## Transport Assessment

Moorebank Intermodal Precinct West – Stage 3 (SSD 10431)  
(Response to Submissions)

Ref: P1277r02v1  
28/07/2020

Figure 5: Network Traffic Volumes, with MPW S2 - Scenario 2

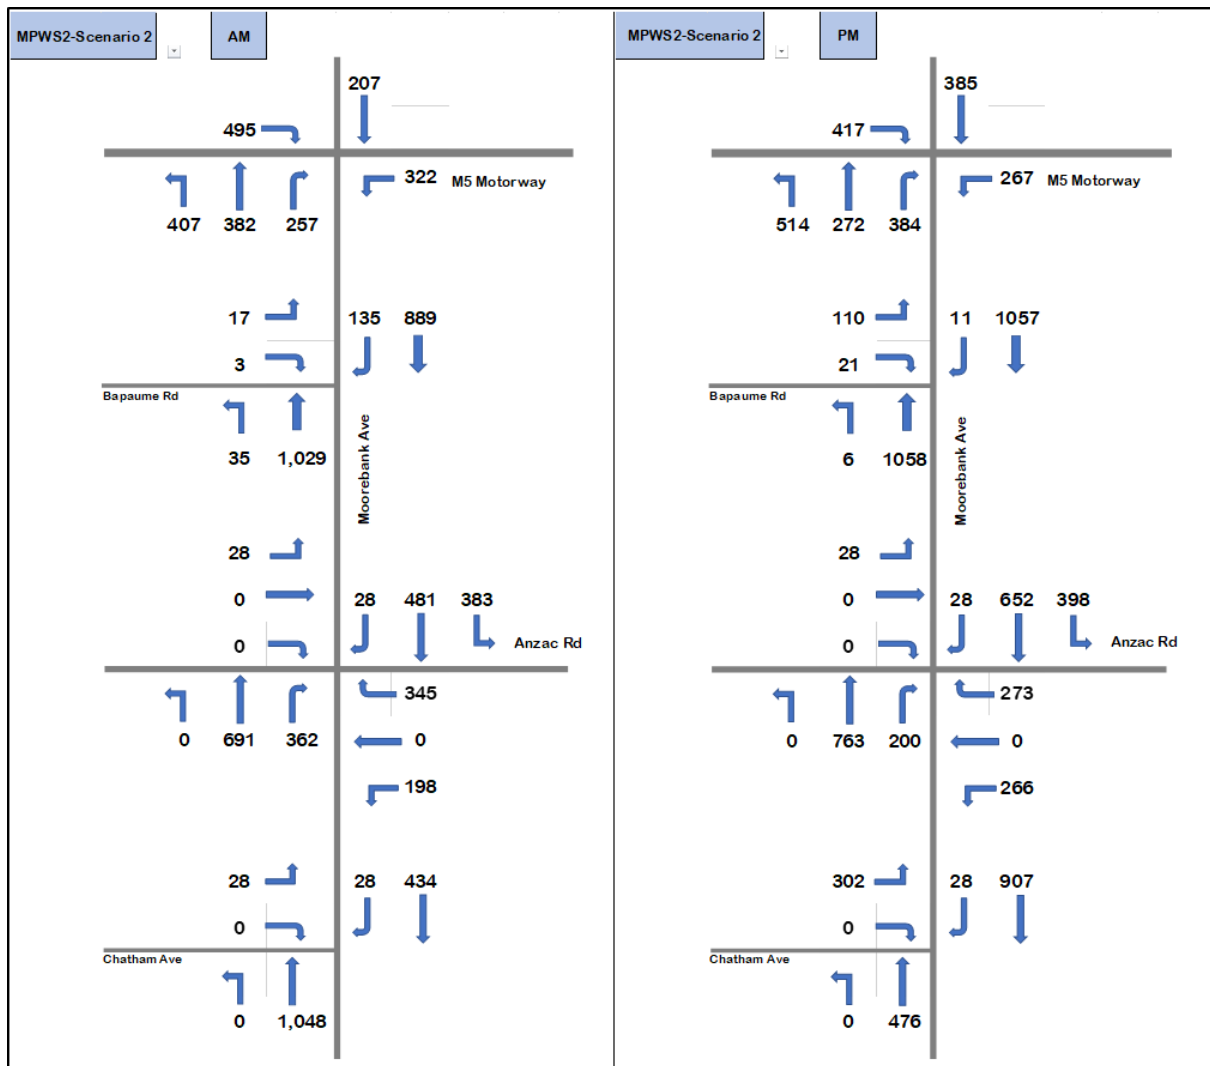
TfNSW Comments	Ason Group Response
<p><b>Network Traffic Volumes, with MPW S2 - Scenario 2</b></p> <p><u>Comment</u></p> <p>It is noted that Figure 5 of the Transport Assessment prepared to support the development application states that the traffic volumes included in Figure 5 are based on the Moorebank Precinct West (MPW) Stage 2 Proposal - Construction Traffic Impact Assessment, dated October 2016 (2016 MPW Report).</p> <p>It advised that:</p> <ul style="list-style-type: none"> <li>Based on the traffic distribution adopted for Stage 2-Scenario 2 in Figure 5 of the Transport Assessment, number of construction vehicle movements included in Figure 5 are lower during the morning peak period and higher during the afternoon peak period compared to the construction traffic movements reported in the 2016 MPW Report; and</li> <li>Morning and afternoon traffic movements for Stage 2-Scenario 2 included in Figure 5 are not the same as traffic movements included in 2016 MPW Report for this scenario.</li> </ul> <p><u>Recommendation</u></p> <p>It is requested that the applicant clarifies the apparent inconsistencies between the Transport Assessment Report and the Moorebank Precinct West (MPW) Stage 2 Proposal - Construction Traffic Impact Assessment, dated October 2016</p>	<p>TfNSW (and other submissions) are referencing an earlier 2016 CTIA report, whereas the submitted report relies on the later 2017 Response to Submissions CTIA report volumes—see below.</p> <div data-bbox="900 777 1358 1417" data-label="Image"> </div> <p>For clarity, the figures adopted came from Figure A-5 and A-6 of that report by Arcadis.</p>
